WEST SUSSEX COUNTY COUNCIL CONSULTATION

TO:	Arun District Council FAO: Michael Eastham
FROM:	Highways, WSCC: Tim Townsend
DATE:	7 th January 2019
LOCATION:	Land off, Burndell Road, Yapton, Arundel
SUBJECT:	Y/97/18/DOC Approval of details reserved by condition imposed under ref Y/19/16/OUT relating to Condition Nos 5, 6, 7, 9, 10, 11, 12, 15, 17, 18, 19, 22, 23 and 24.
DATE OF SITE VISIT:	
RECOMMENDATION:	☒ Advice ☐ Objection ☒ Modification ☐ No Objection ☐ More Information ☐ Refusal
S106 CONTRIBUTION TOTAL:	£N/A for this application (secured at outline stage)

Scale	Date	Designed
1:500 @A1	NOV 18	SG
Drawn	Checked	Approved
SOM	LH	RS
Job No	Drawing No	Rev
18-070	18-070/103	A

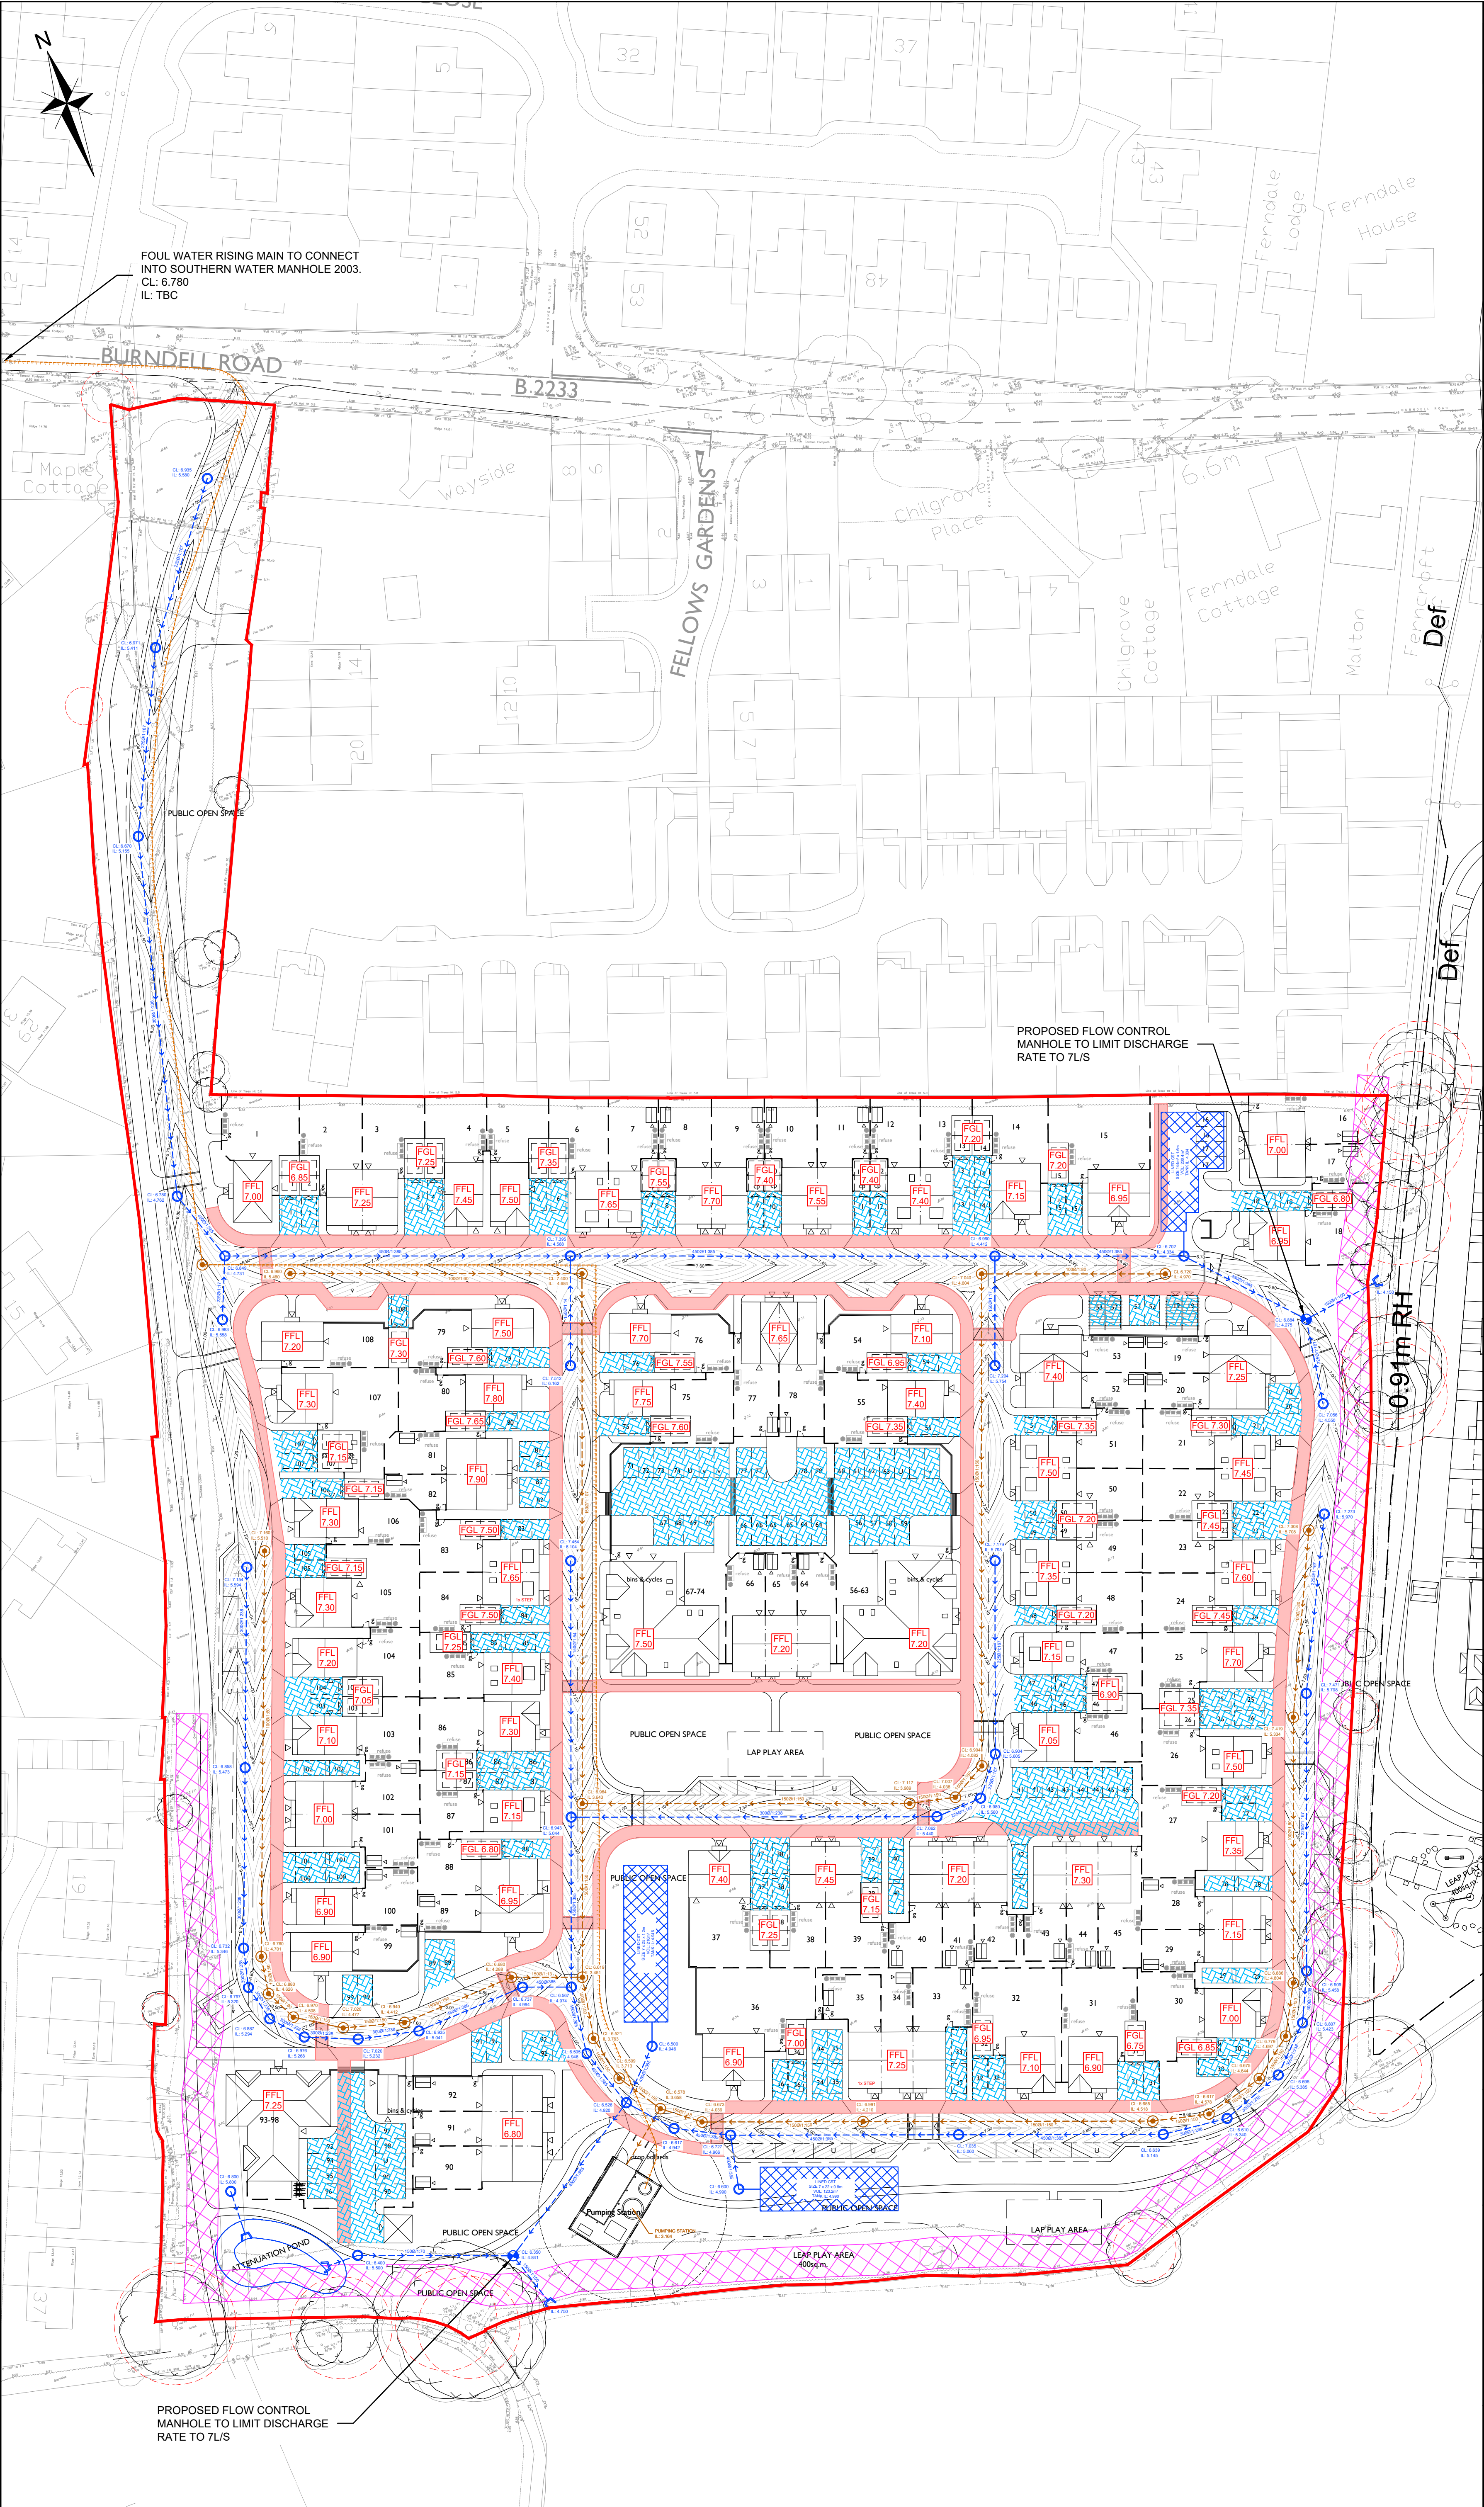
- 4. Condition 23 (cycle parking)** – The cycle parking for properties 93-98 (south-western corner of the site) should be shown covered and secure. Drawing 18-070/103 does not appear to show this. The case officer should ensure that the cycle parking for all units is provided secure and covered.
